BOCC  
CDS  
PA

Today I am adding comments to the record regarding 3BR custom cuts slaughterhouse/feedlot project. In this document I will be detailing comments regarding the letter for mitigation plan and the most current SEPA.

## **COMMENTS ON (REVISED) SEPA APPLICATION FROM 4-4-23**

3200 Wilson Creek Road

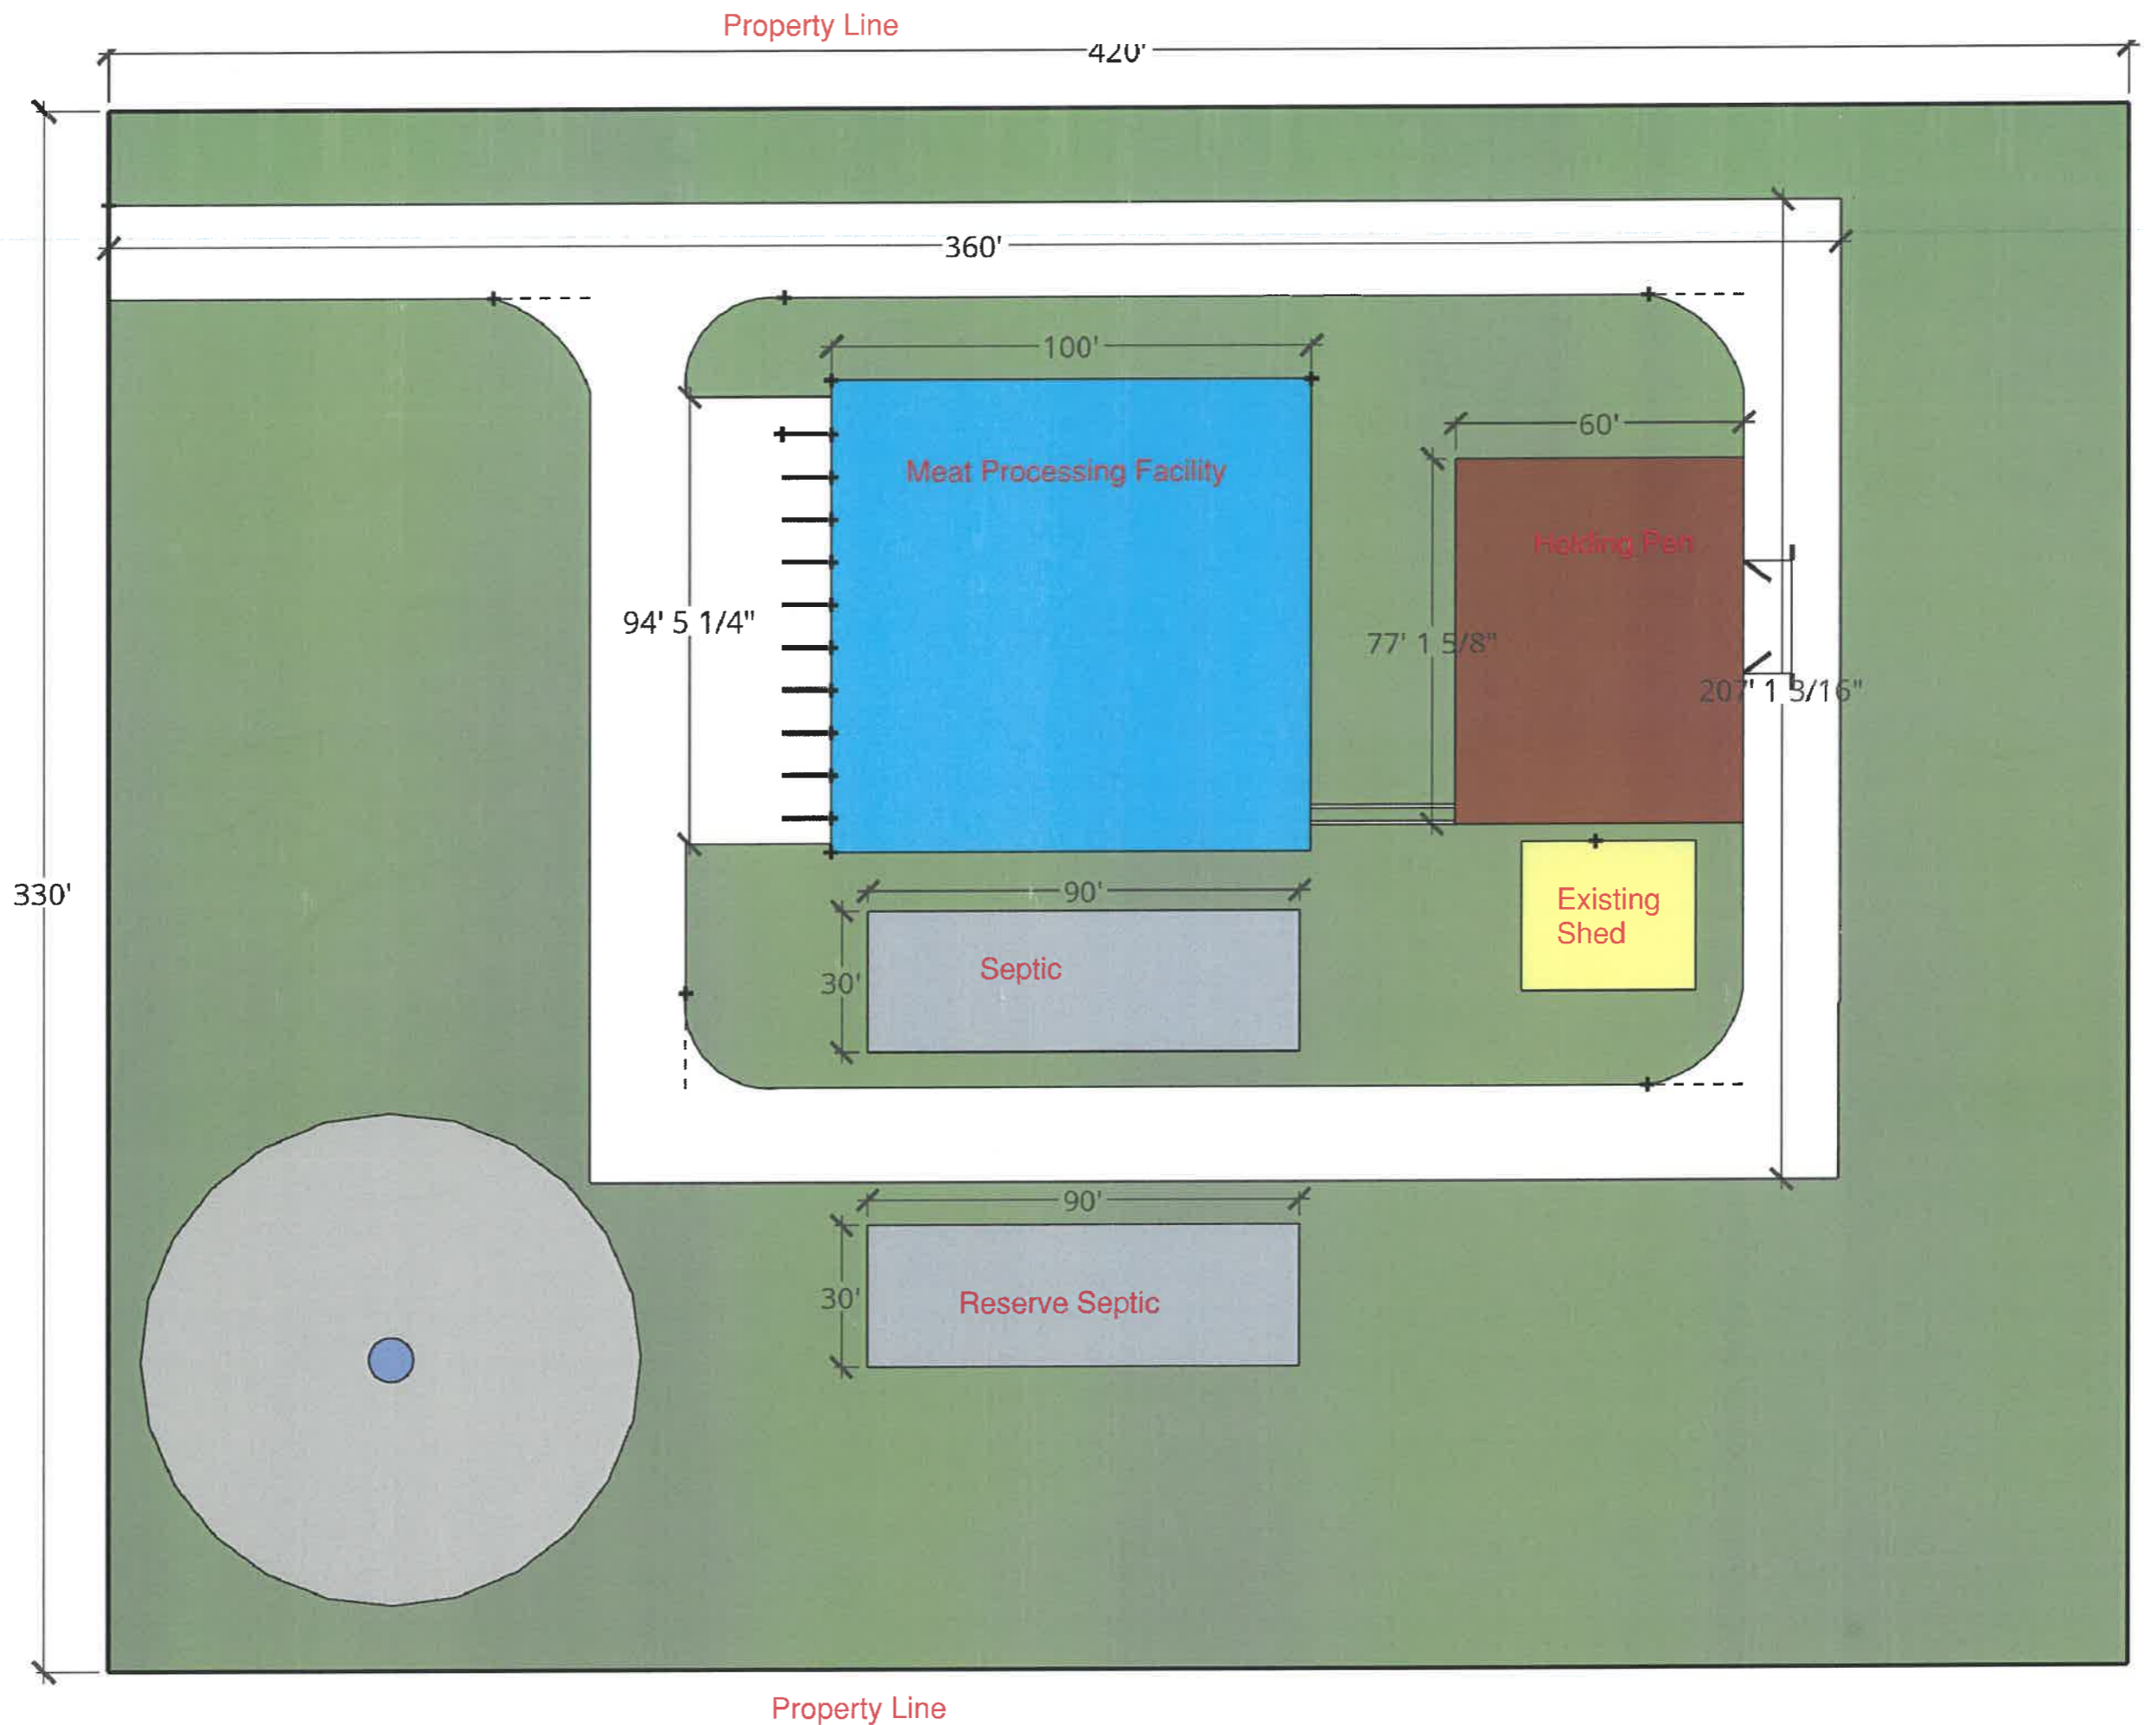
The current site plan has the holding pens and facilities up gradient from the current stock well and flood area.

All the stormwater runoff, waste from the holding pens, and contaminated water from washdown facilities would have a great potential to drain towards the well and flood area draining into Wilson Creek ditch.
